Dogger Bank South Offshore Wind Farm

**Appendix H2 to the Natural England Deadline 2 Submission**  
**Natural England's comments and advice on Offshore Ornithology Compensation**

Planning Inspectorate Reference EN010125

27<sup>th</sup> February 2025

Co-ordinate system: WGS 84 / UTM zone 31N Page Size: A3 Scale: 1:1,200,000

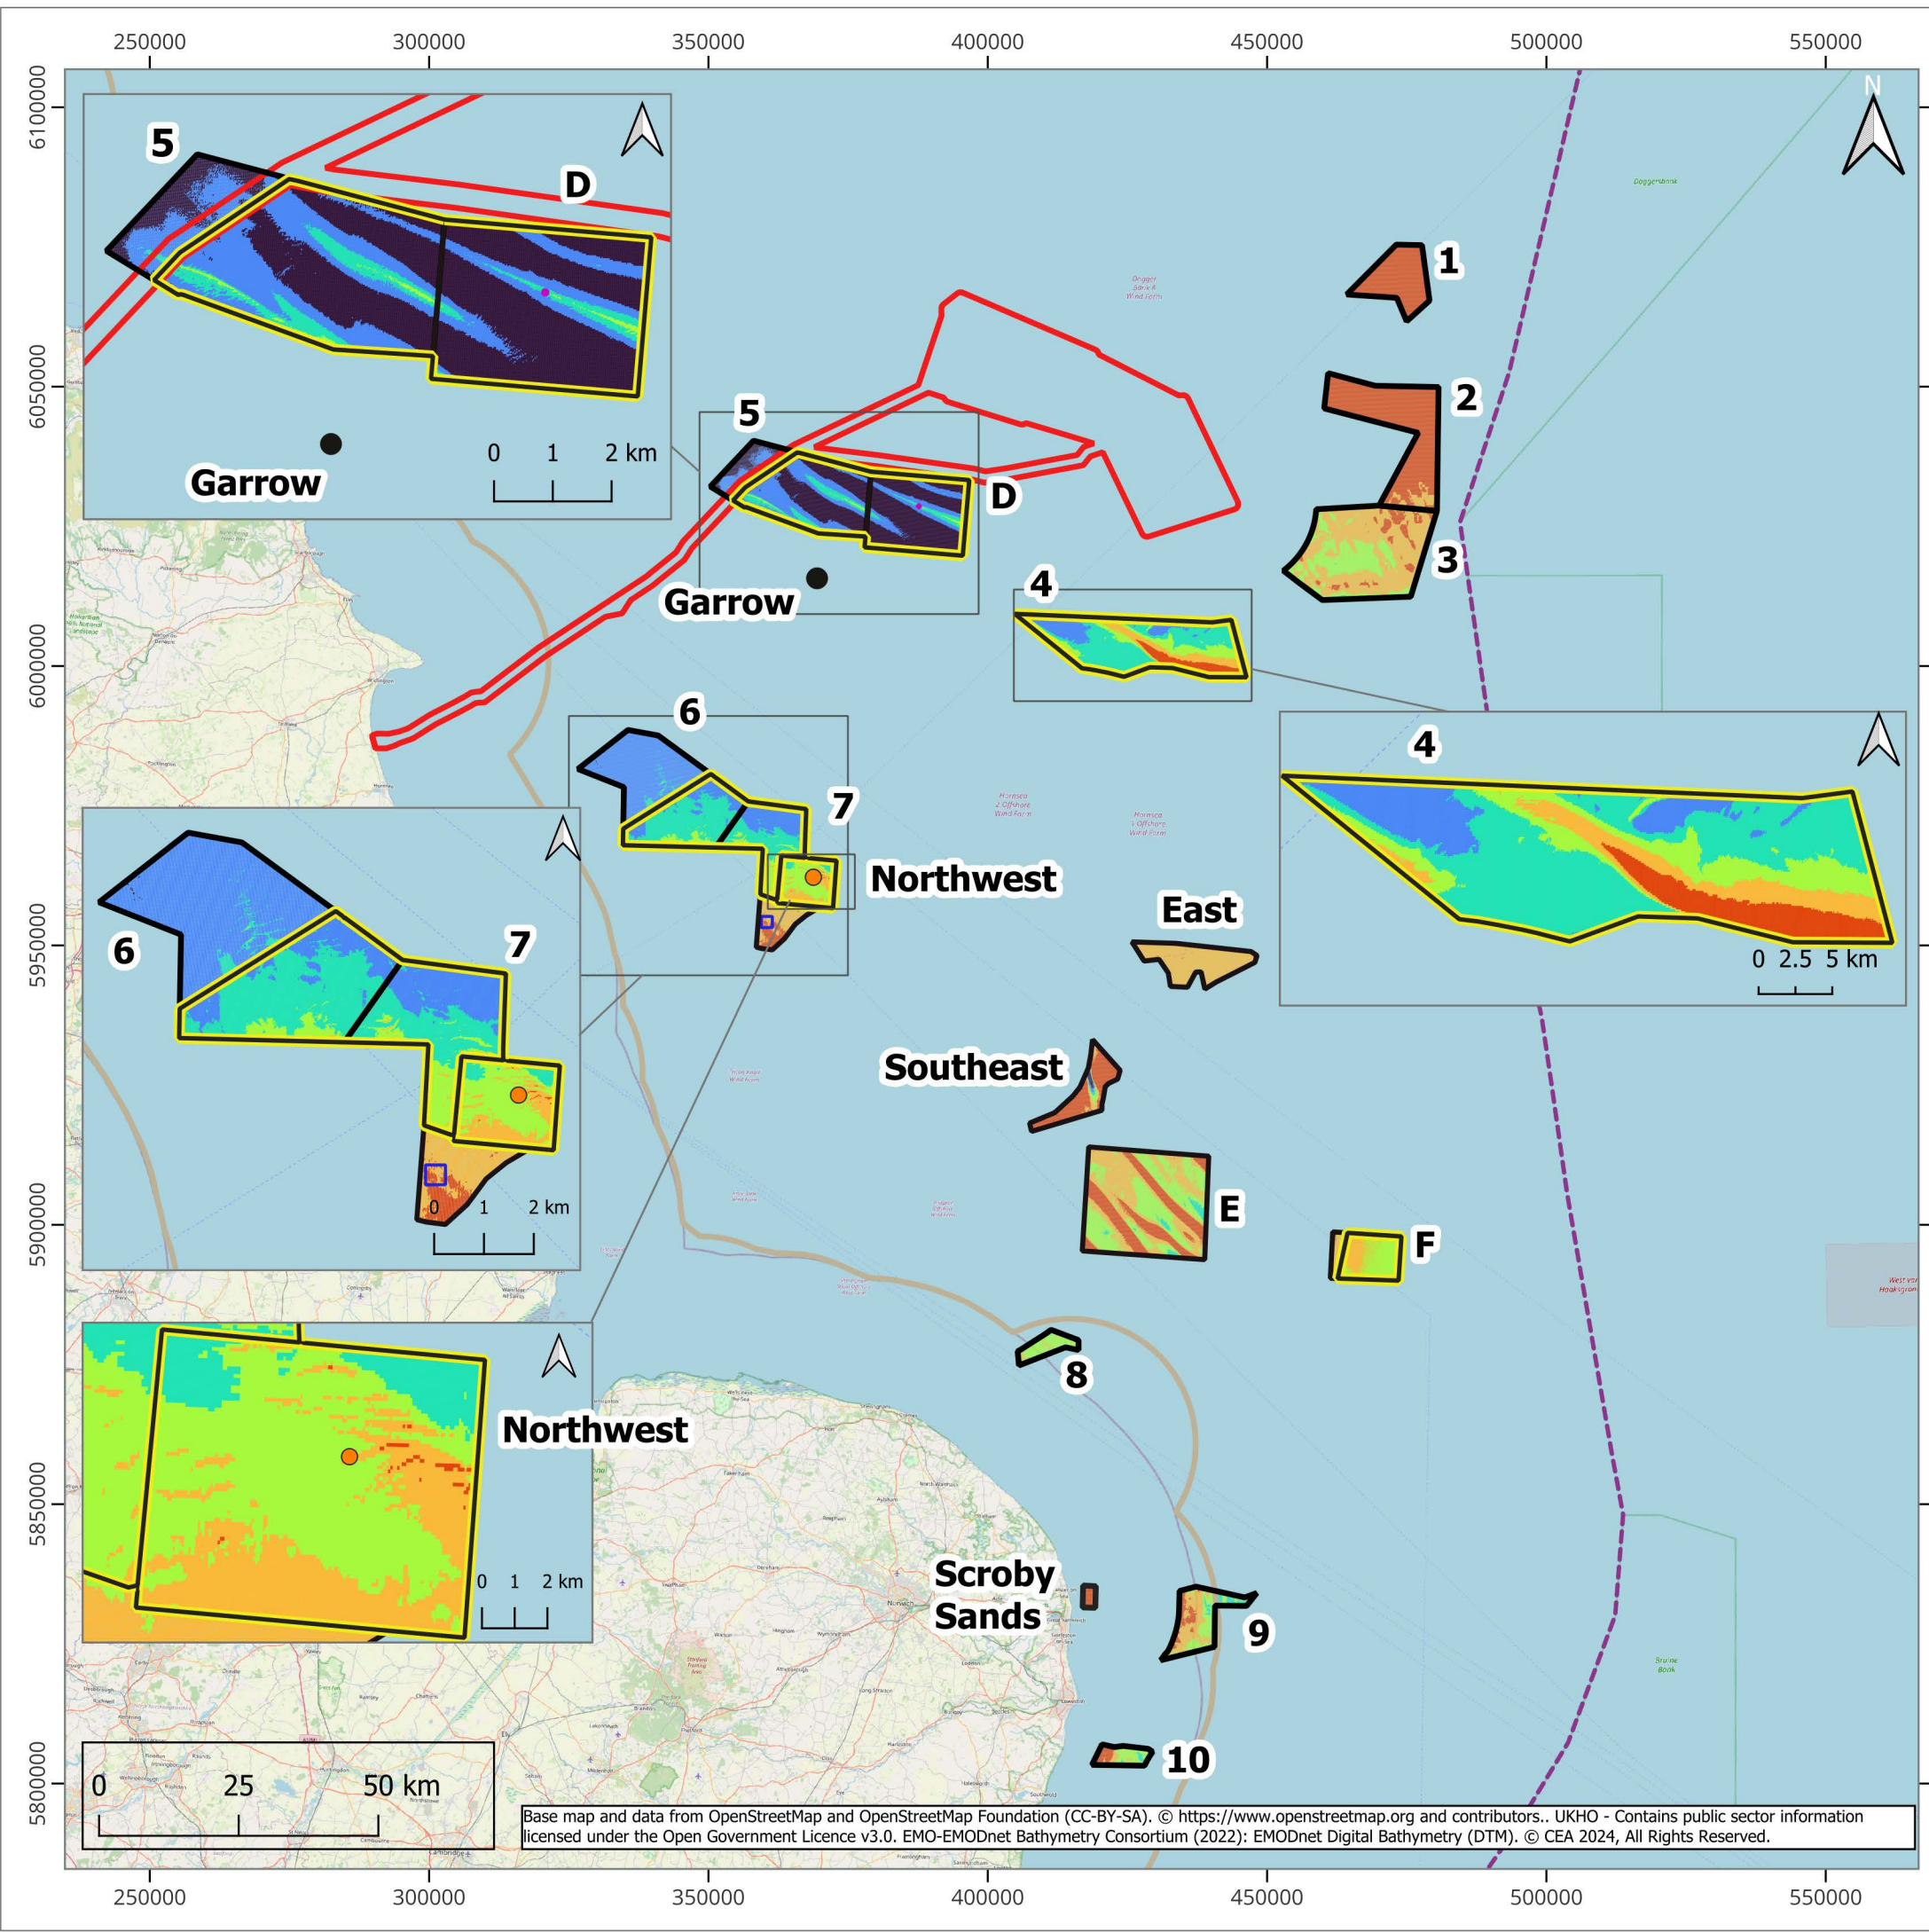
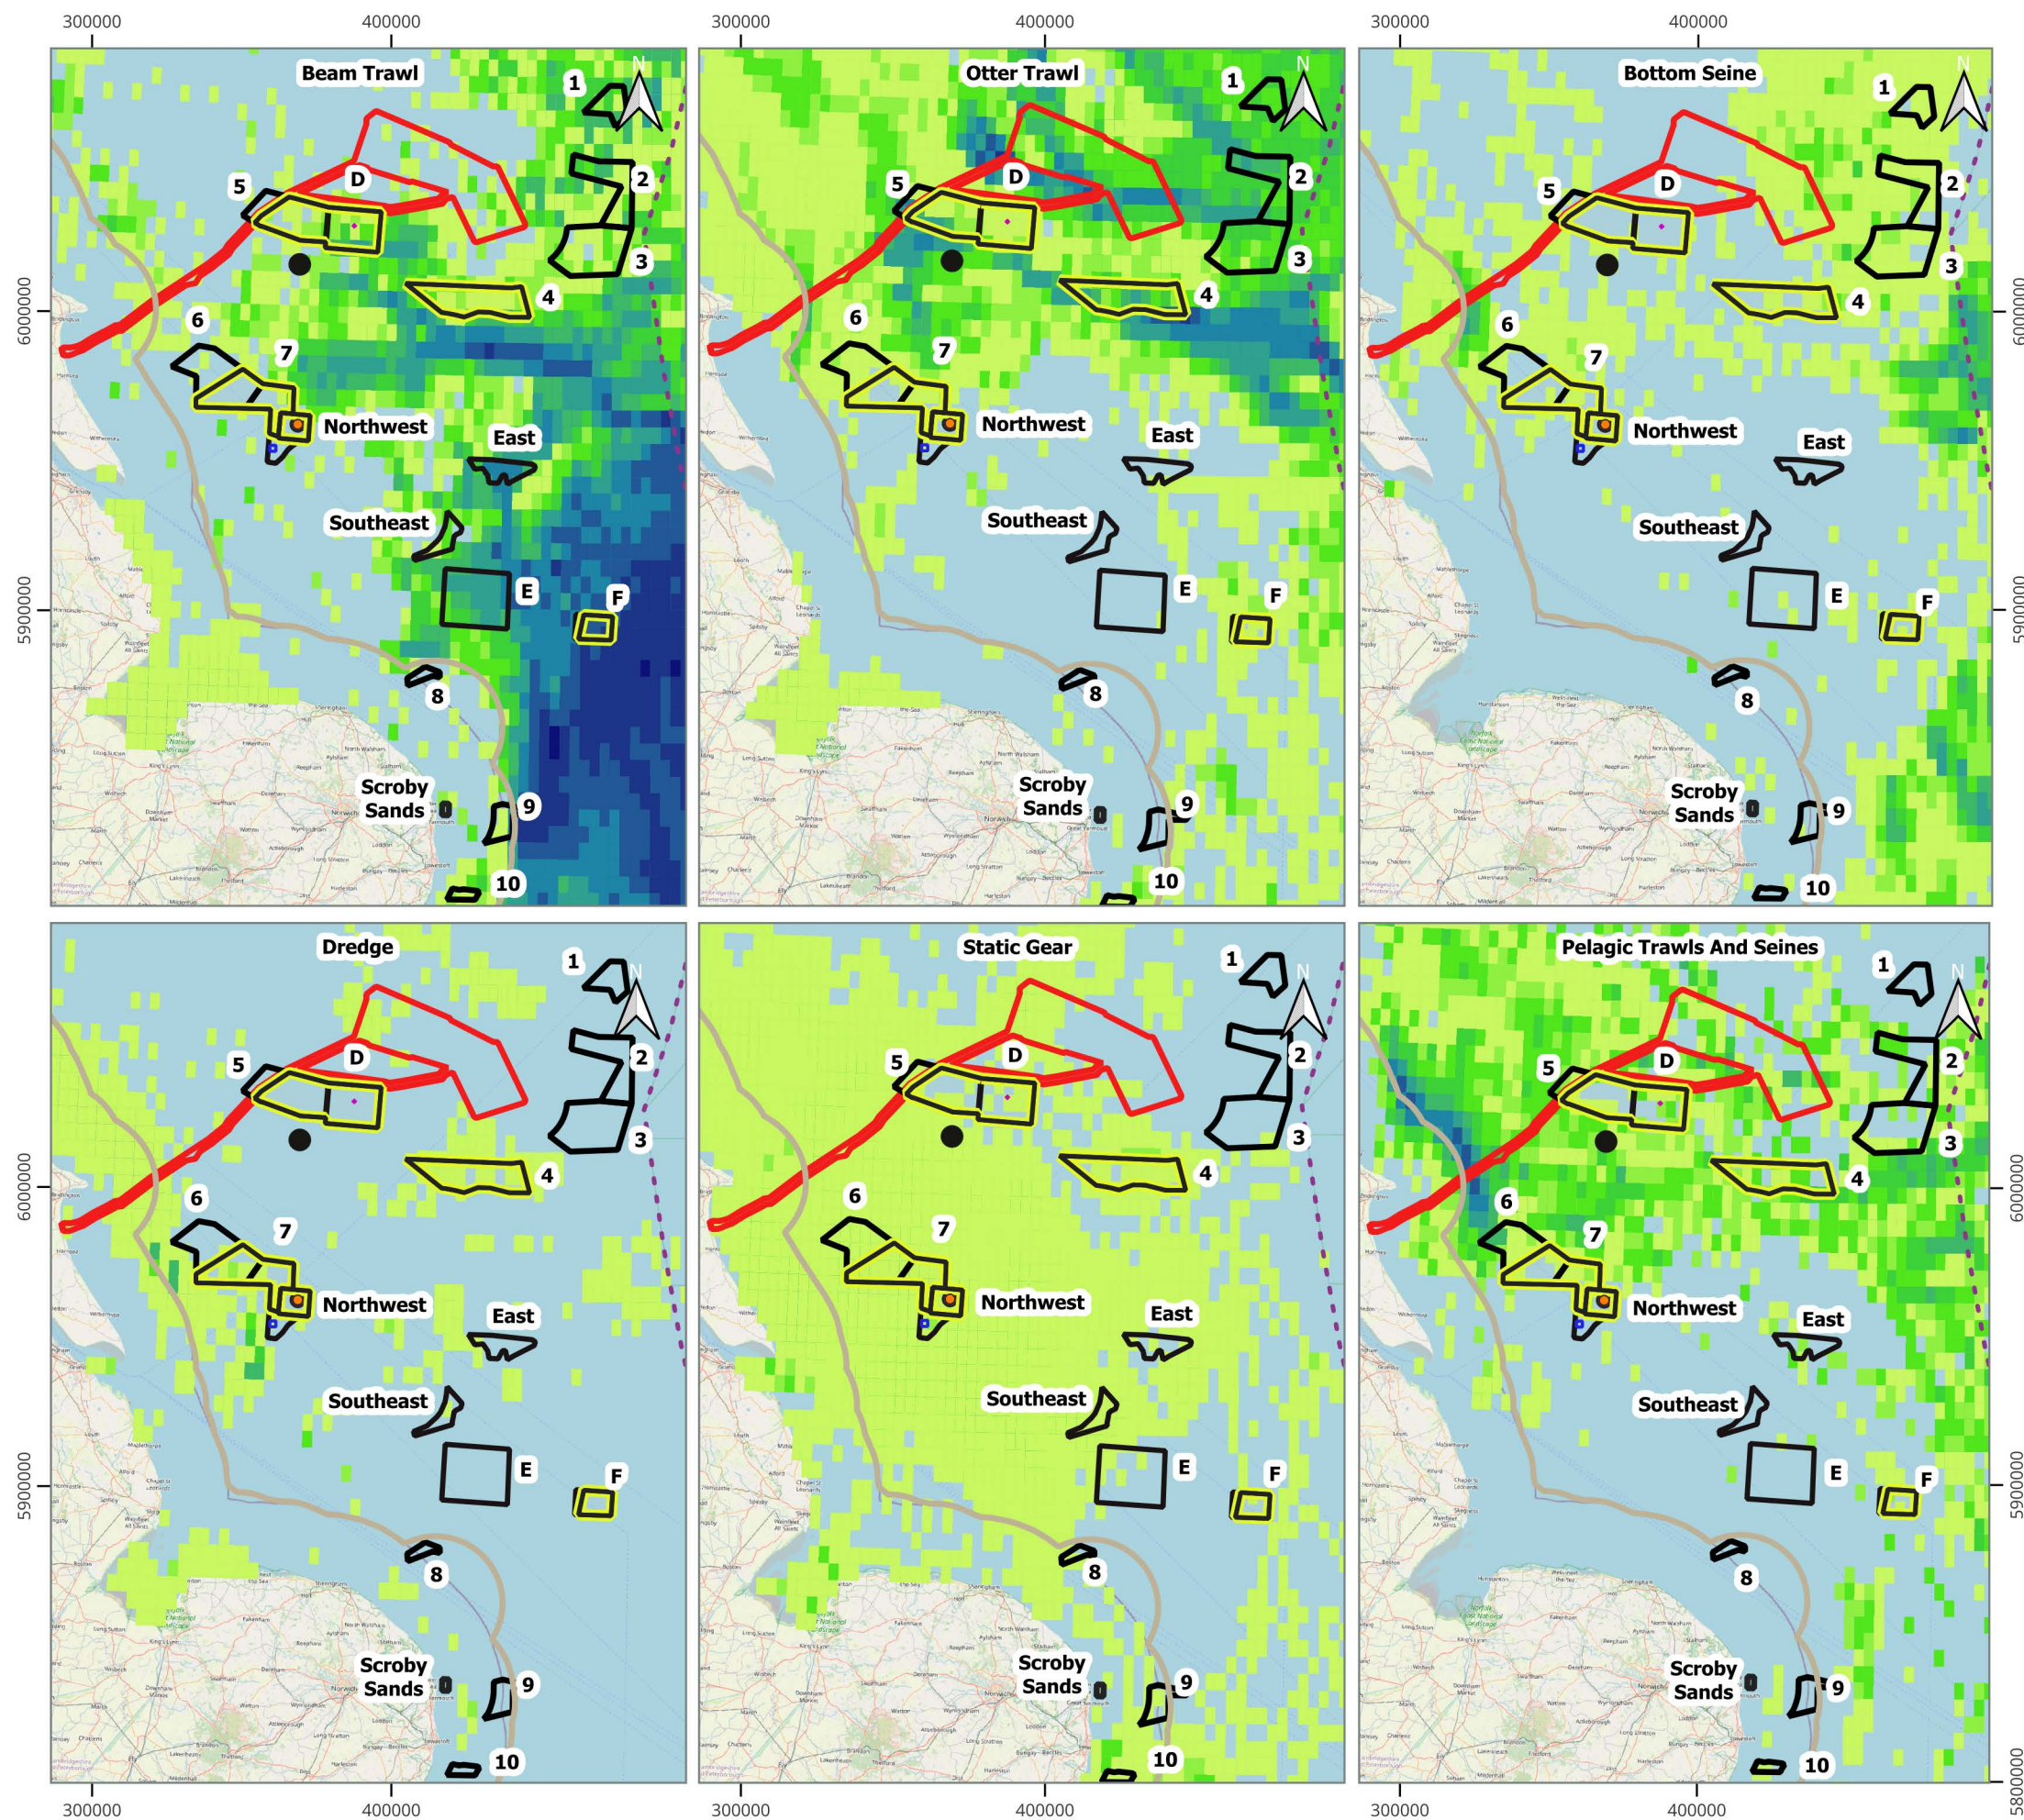
- Site F - We welcome that the area that overlapped with the North Norfolk Sandbanks and Saturn Reef (NNSSR) SAC has been removed from the Area of Search.
- Sites 4 and 5 - As per our Relevant Representations advice, we highlight that these sites appear to be within the buffer zones for DBS and the Hornsea Zone offshore wind farms (OWF). Consideration should be given to a greater degree of collision risk for a colony established here.
- 6, 7 & North-West - These locations are not as far inshore as the original 'West' location, however consideration should still be given to the likelihood of competition with birds foraging from FFC SPA. We advise the Project to look into any overlap with these areas in available kittiwake utilisation distribution maps (e.g. Cleasby et al. 2020, Waggitt et al. 2020). For site

6 it would also be beneficial to present the minimum distance to Flamborough Head, for consideration of the Yorkshire Wolds AONB.
